Rimington & Middop Parish Council

Responses to recent planning applications

0803 Redevelopment of Ox Close Farm

# 3 20140803 P Site Plan of bb7 4ej

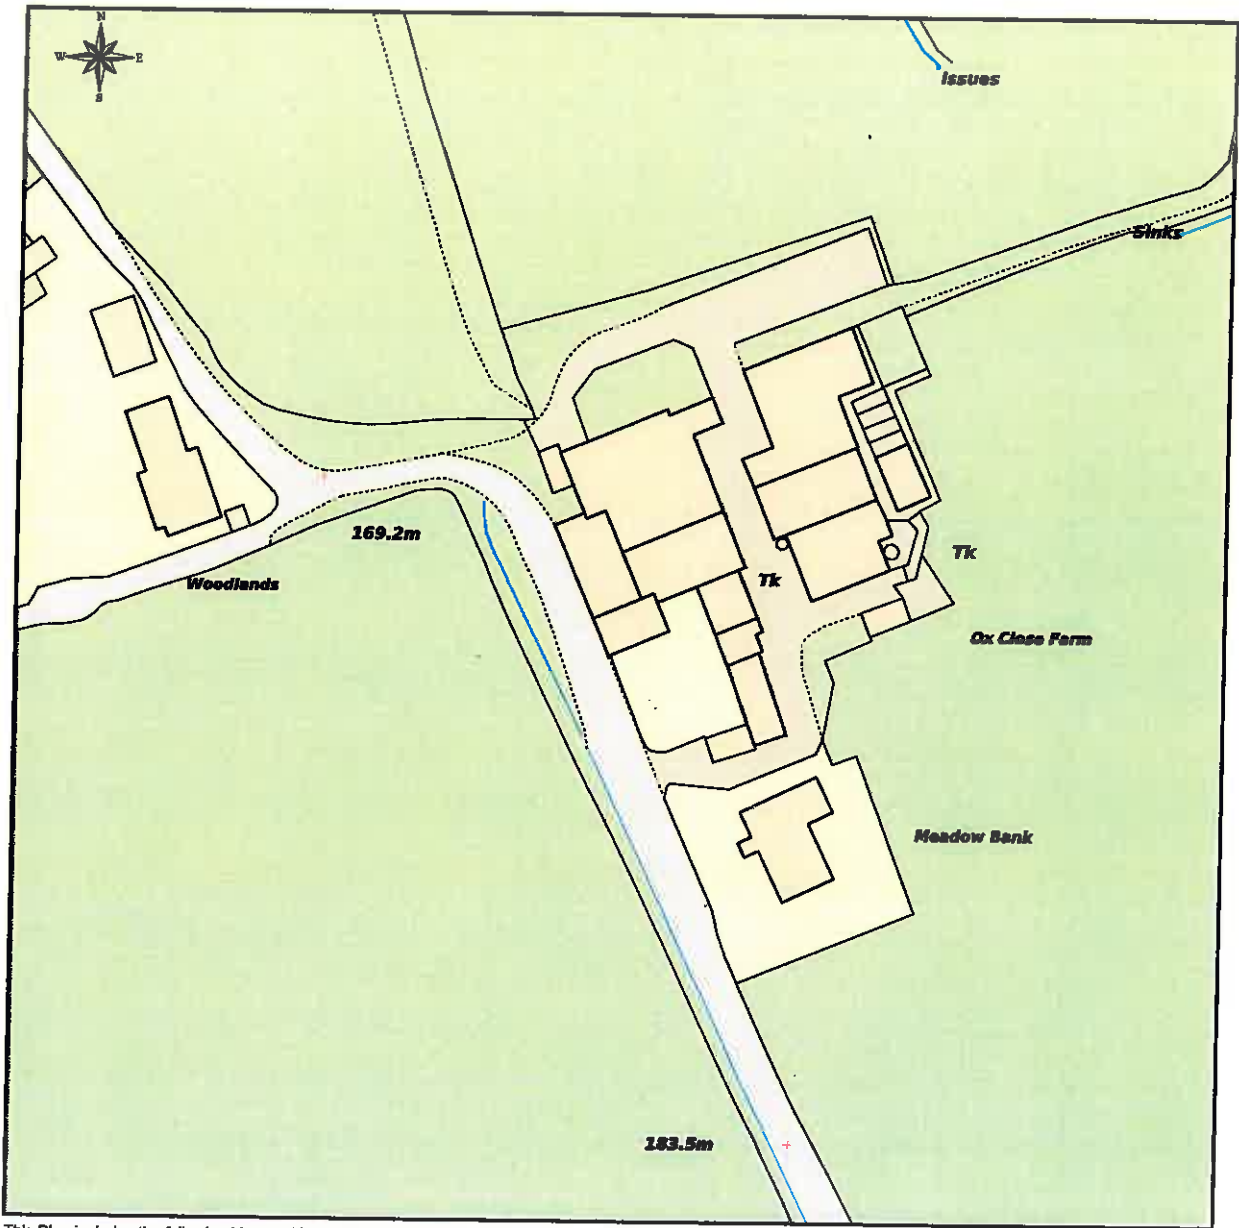
The P C have no objections to this development but they draw your attention to the absence of the footpath on the site maps. This path is used by Villagers and needs to be preserved. Please make sure that the developers have this in mind.
